**Crossroads Mixed Use
Traffic Study**

PCD File No. SF-21-029 & PPR-21-41

El Paso County, Colorado

Re: Crossroads Mixed Use Traffic Study Letter (PCD File No. SF-21-029 & PPR-21-41)
SWC of Meadowbrook Parkway and Newt Drive
El Paso County, Colorado

FINAL PLAT  
CROSSROADS MIXED USE  
FILING NO. 1  
JOB NO. 18-003  
DATE PREPARED: 06/23/2021  
DATE REVISED:

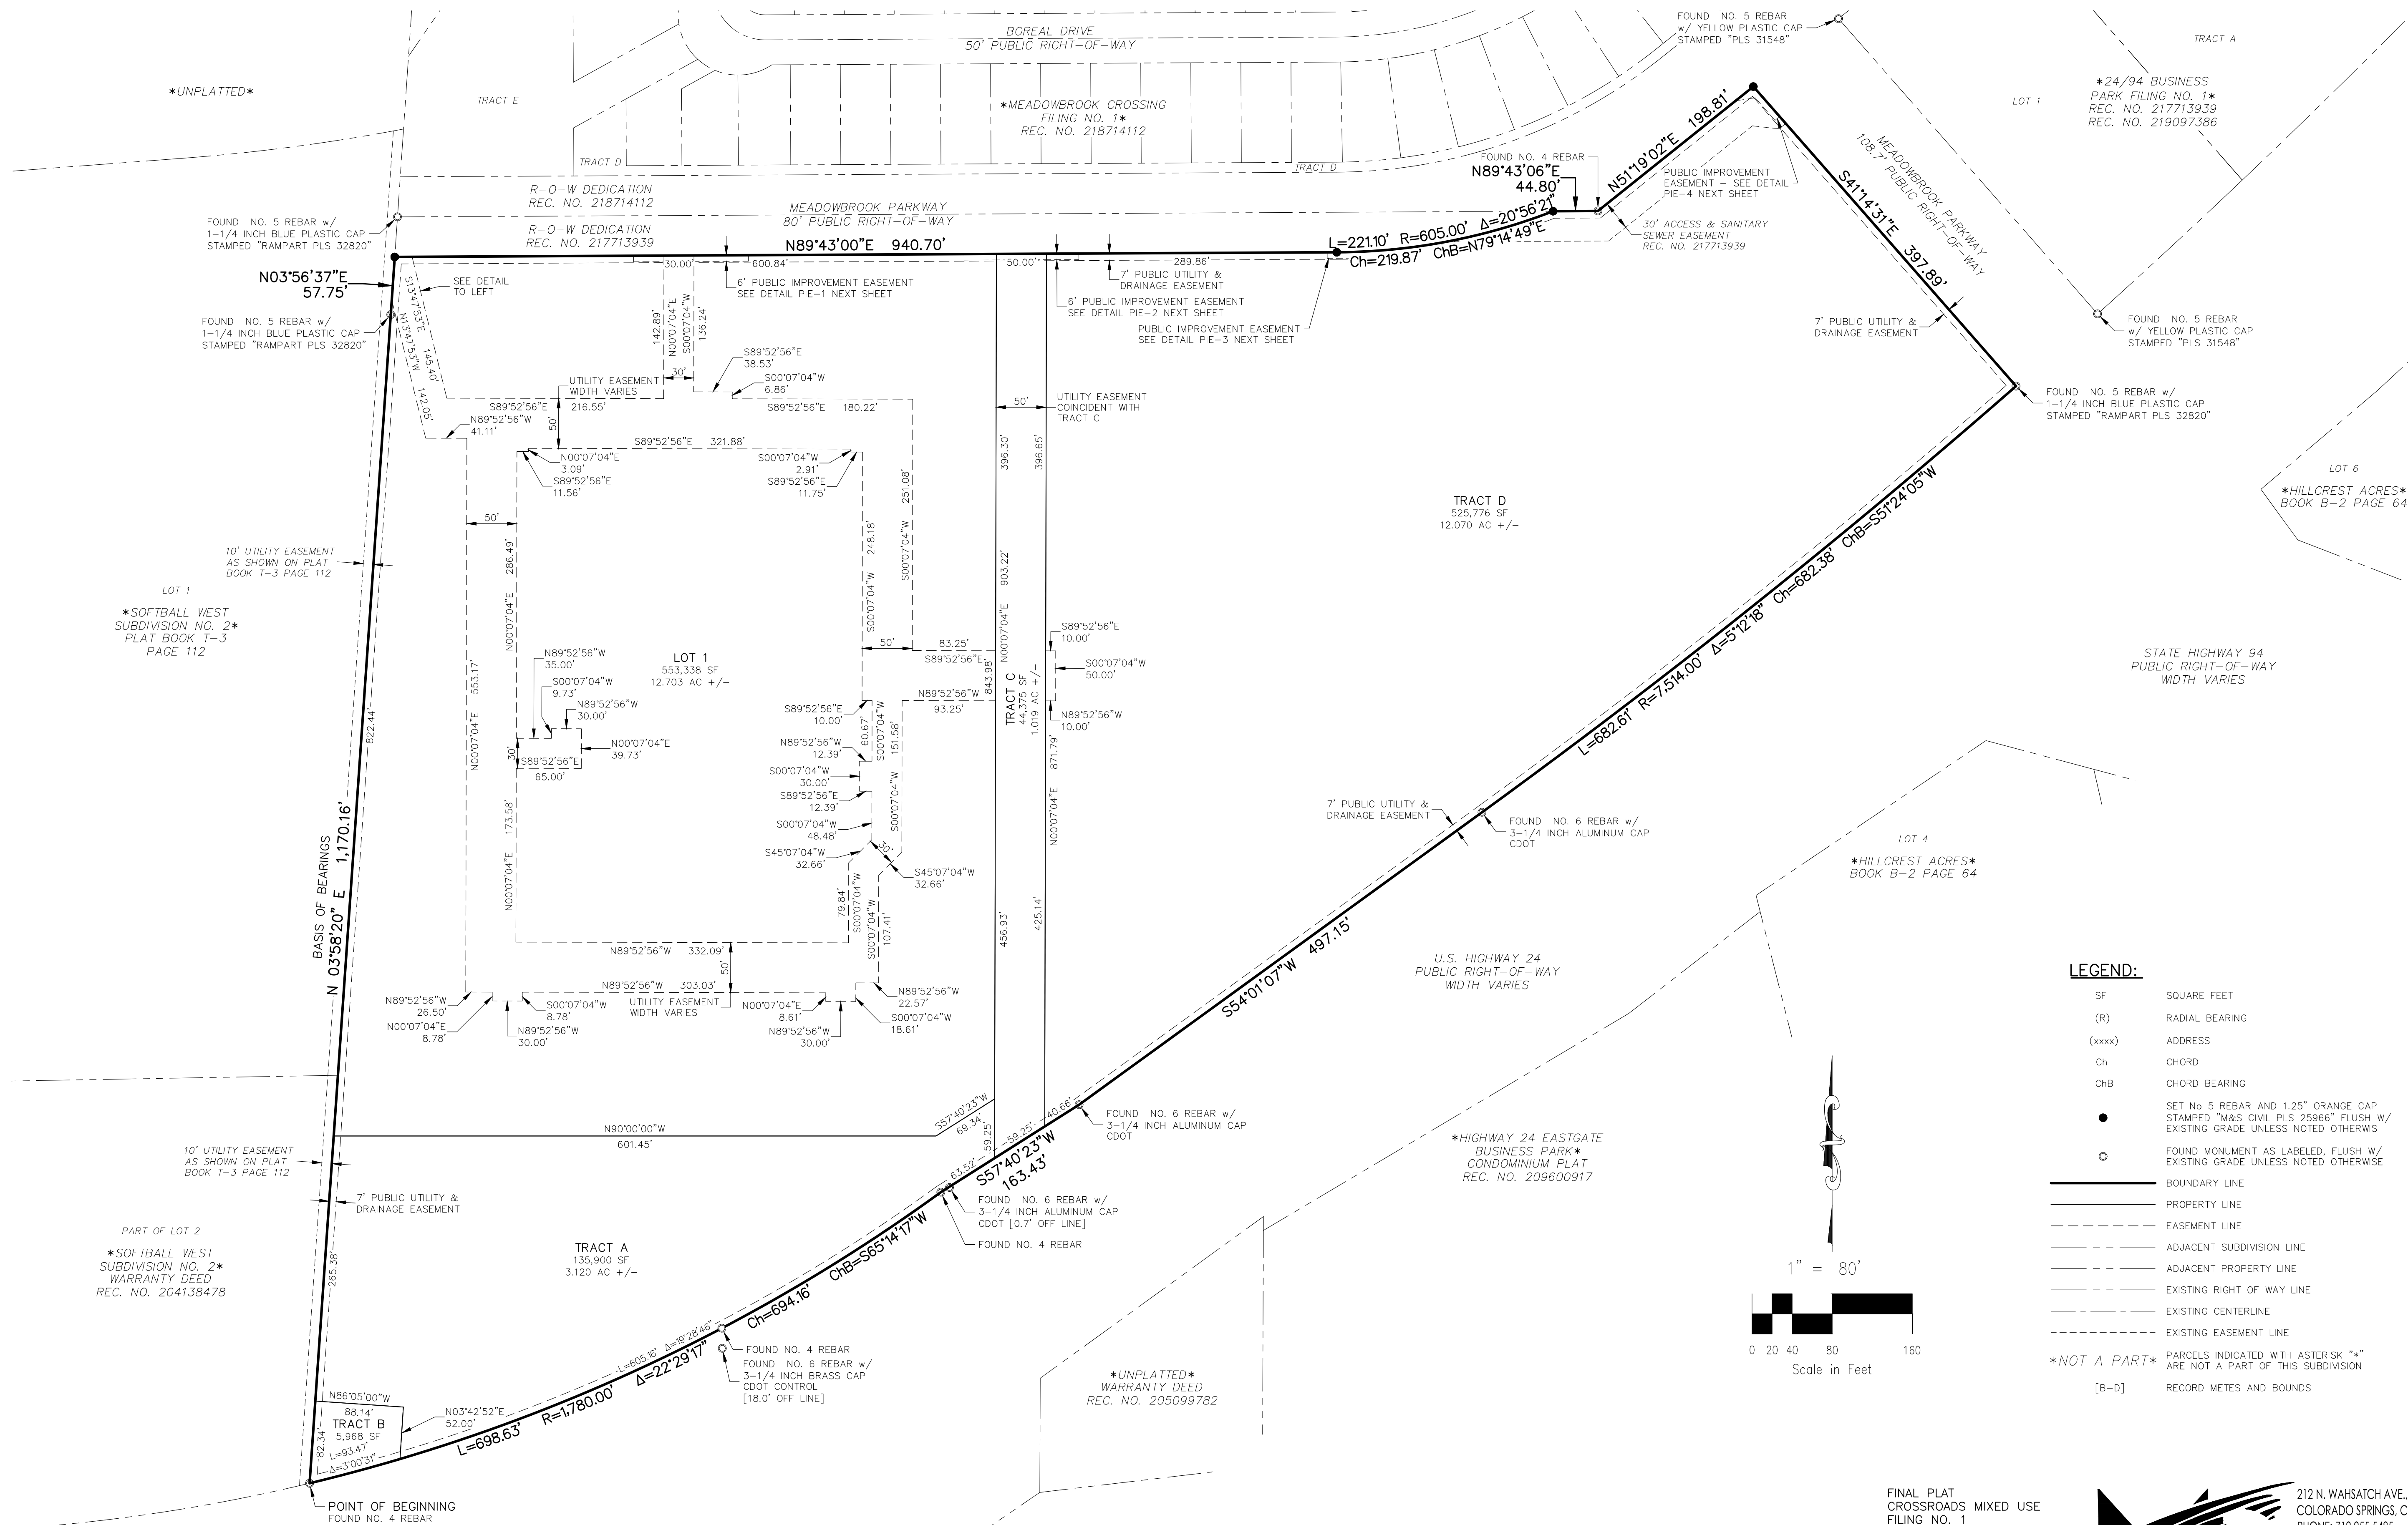
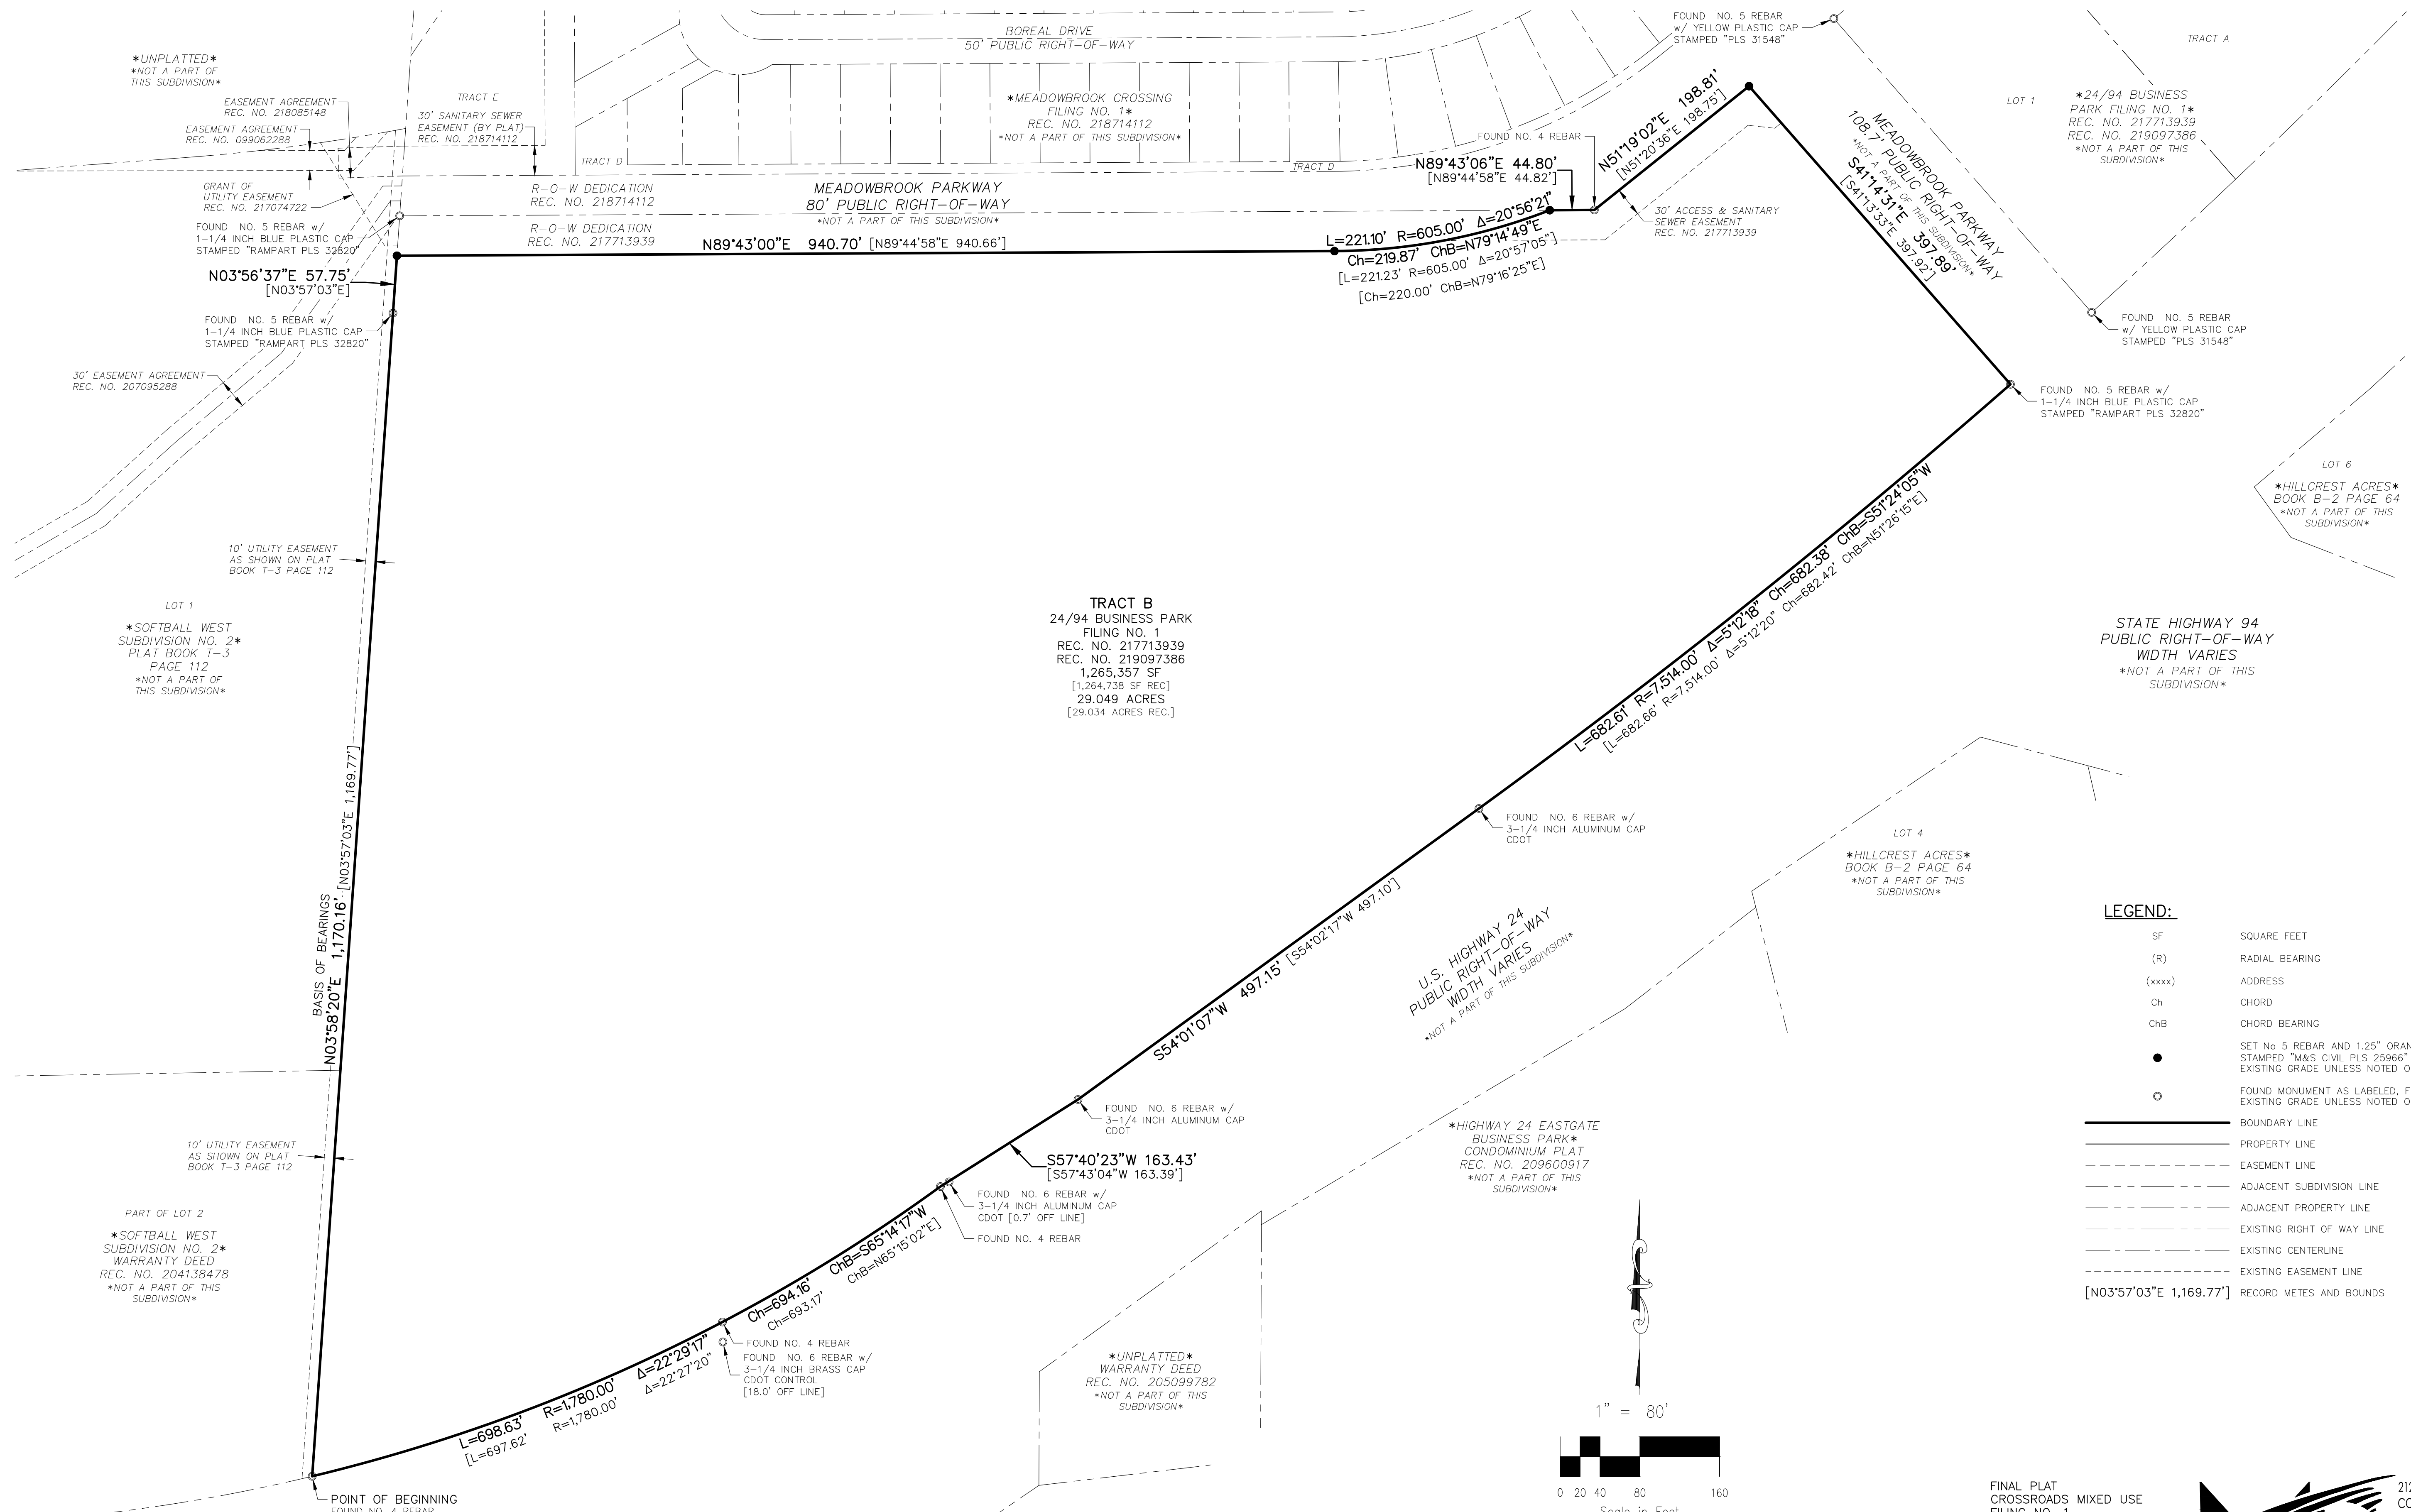
Update . The current application is the final plat process, determination is required at this time. Plat note 19 would need to be updated if the developer is requesting inclusion into a PID.
